# Woodhead Road Honley

Road Safety Audit

Stage 1

**Designers Resonse**

ROAD 3 VERTICAL TRACKING

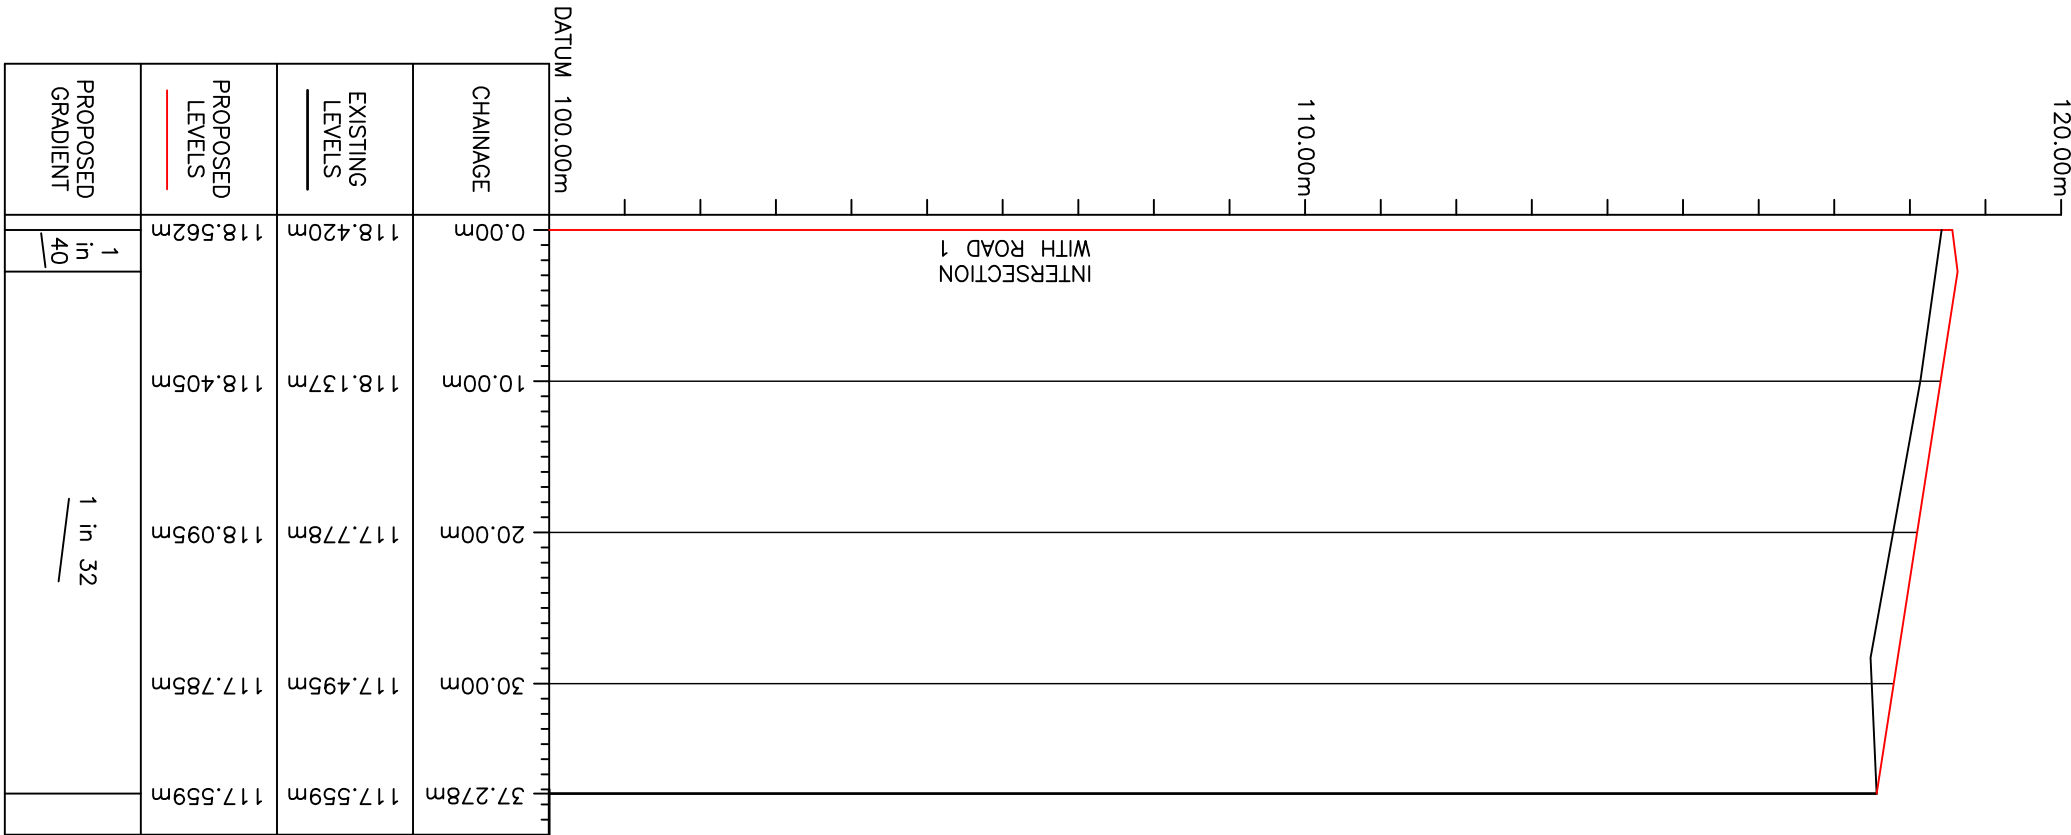
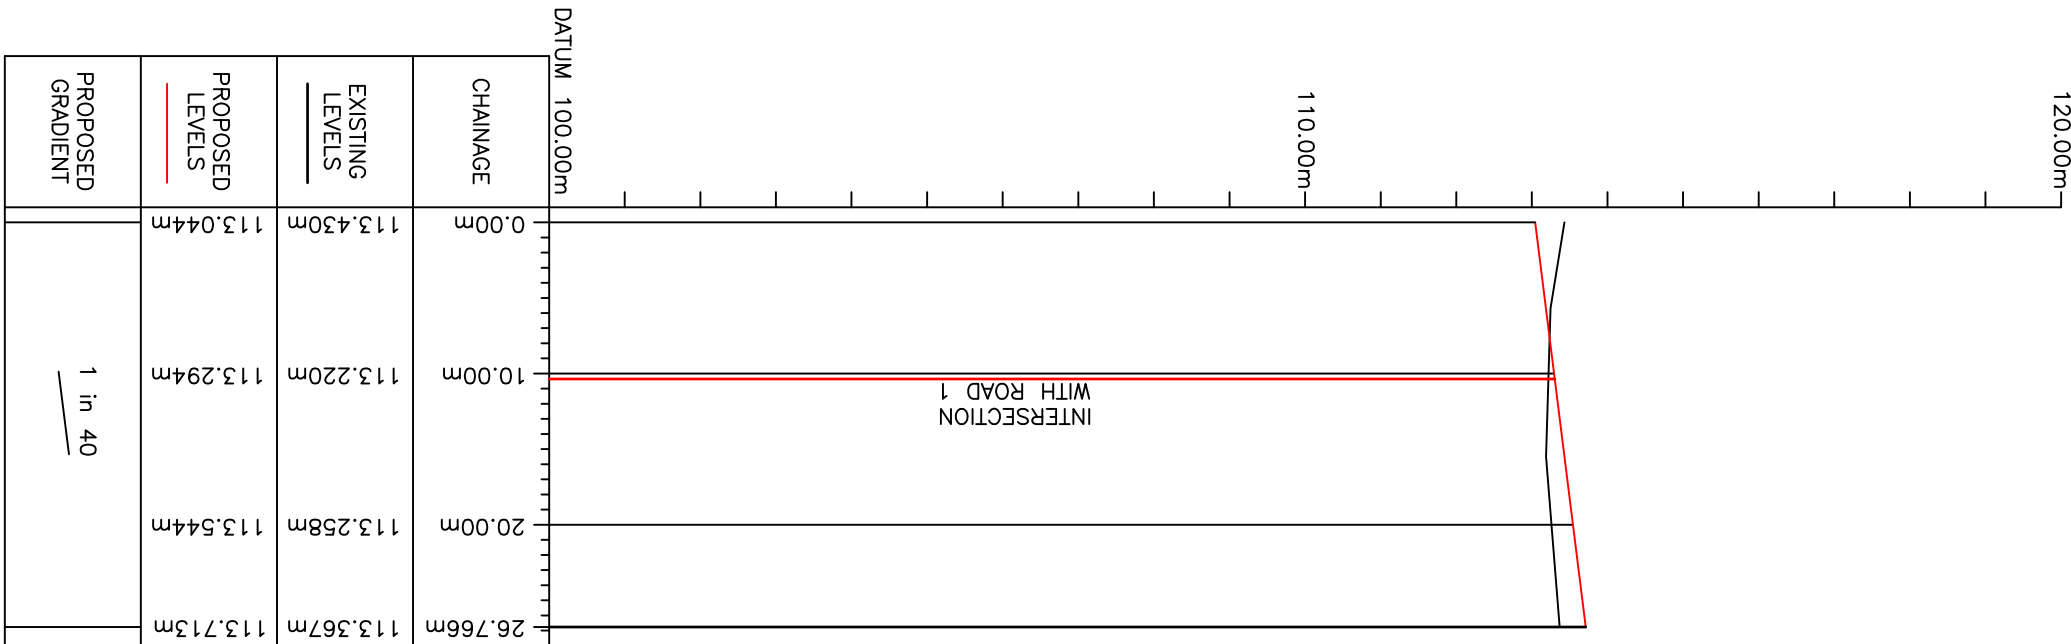
**Detail:** Swept path analysis has been shown for most of the site but it is unclear whether a refuse vehicle can access the first, second and third cu-de-sac safely especially at the junctions with the main spine road. Vertical tracking and long sections have only been detailed for two of the 5 cul-de-sacs so it is also unclear whether the gradients are acceptable and can be safely negotiated by a larger vehicle. It appears that a refuse vehicle will have to reverse from the fourth cul-de-sac as there is no turning facility which increases the risk of a collision with other vehicles or pedestrians.

**Recommendation:** Ensure all movements are safe in and out of the cul-de-sacs especially for larger vehicles and the gradients can be negotiated.

Bin collection points to be provided at the junction of the private drives with the main spine road.

Maximum gradient of the private drives to be 1 in 8 unless agreed otherwise with KMC.
